Tel: 01903 737756
Email: planning@arun.gov.uk
www.arun.gov.uk/planning
Please ask for: Ms Ella Summerfield
Email: ella.summerfield@terraquest.co.uk
Telephone: 0121 2341390
Our Ref: LU/200/26/HH
Your Ref:
Date: 21st August 2026

Application for Planning Permission for Works or Extension to a Dwelling

Development: Proposed side extension.
Location: 111 Oakcroft Gardens Littlehampton BN17 6LU

Site Plan 1:500

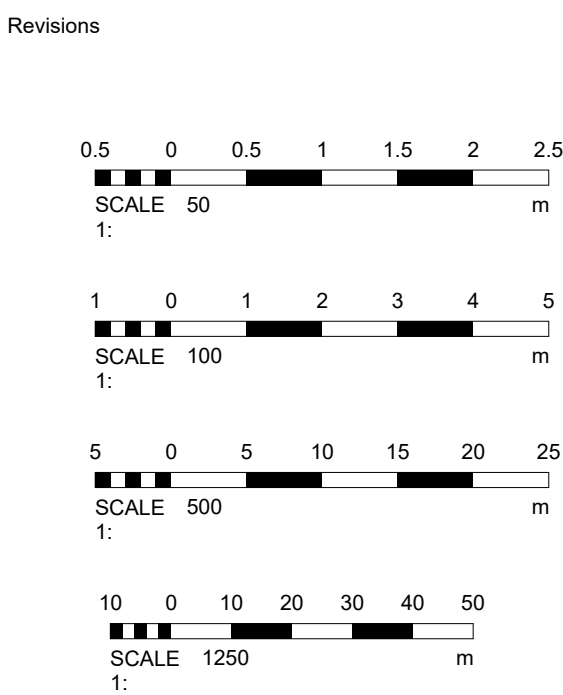
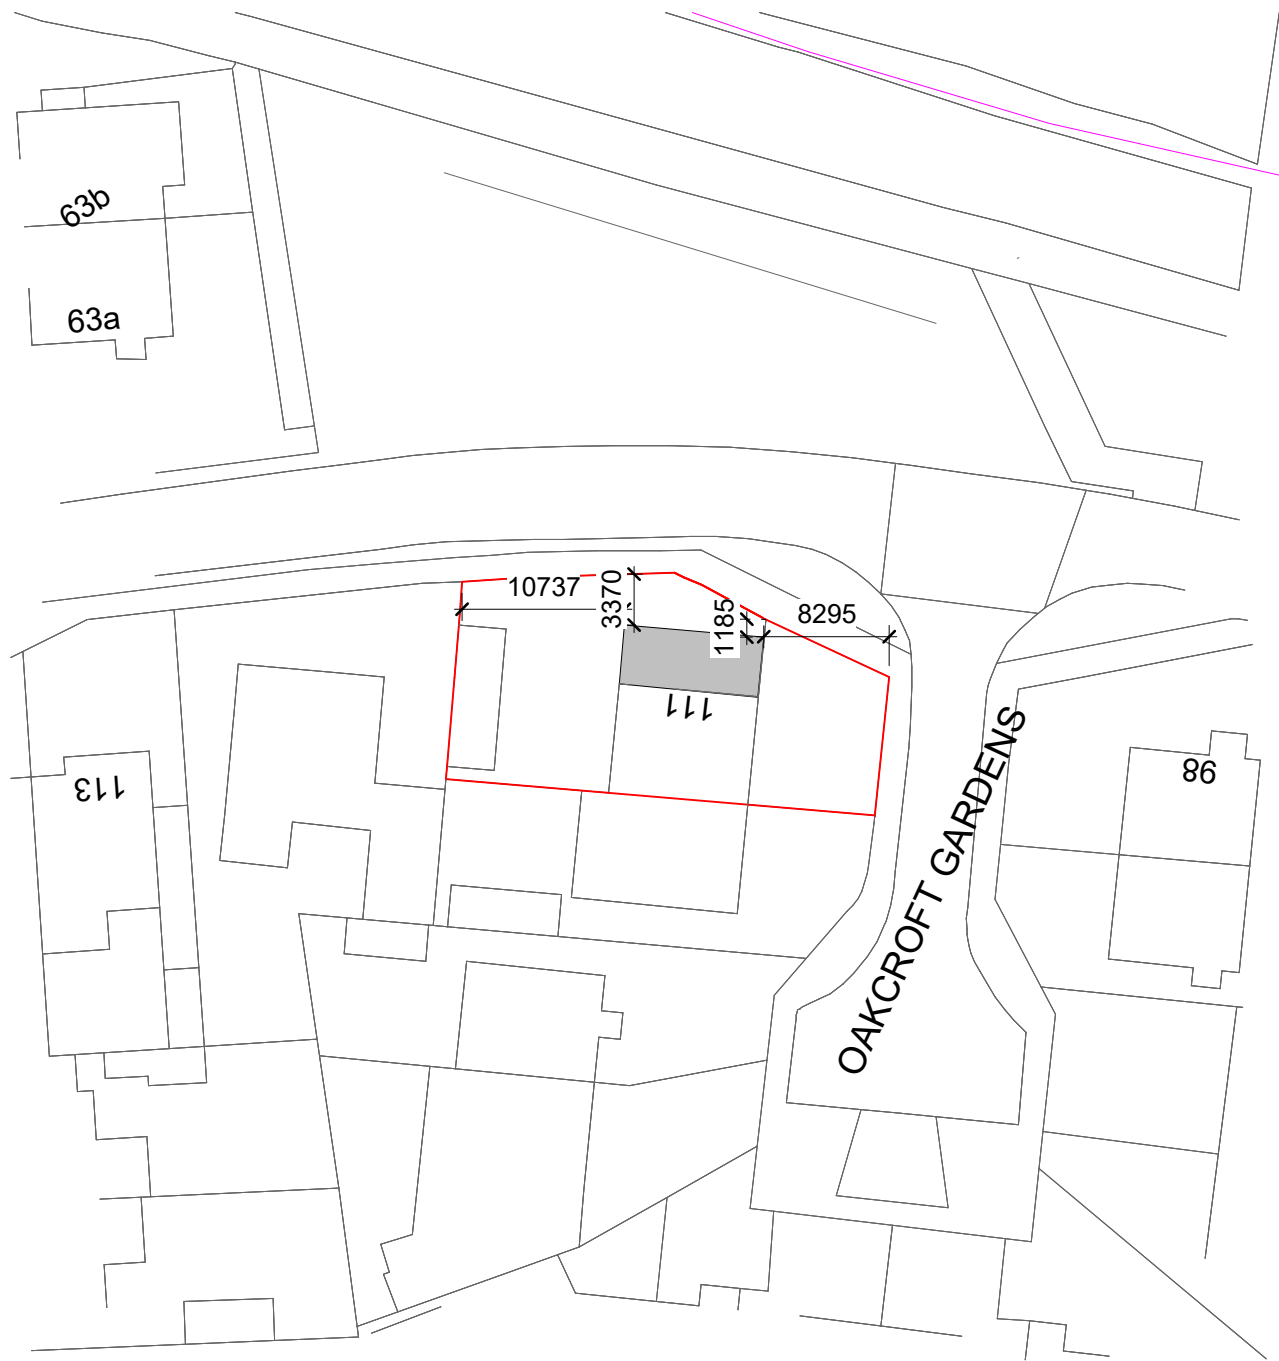
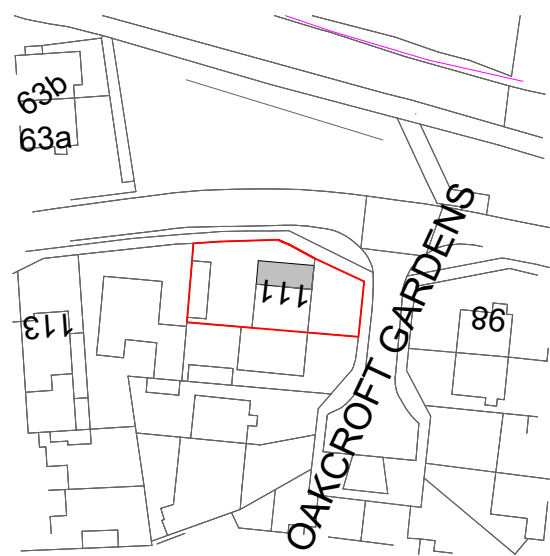
Block Plan

You are required to have dimensions from the proposed extension(s) to all site boundaries. Please amend
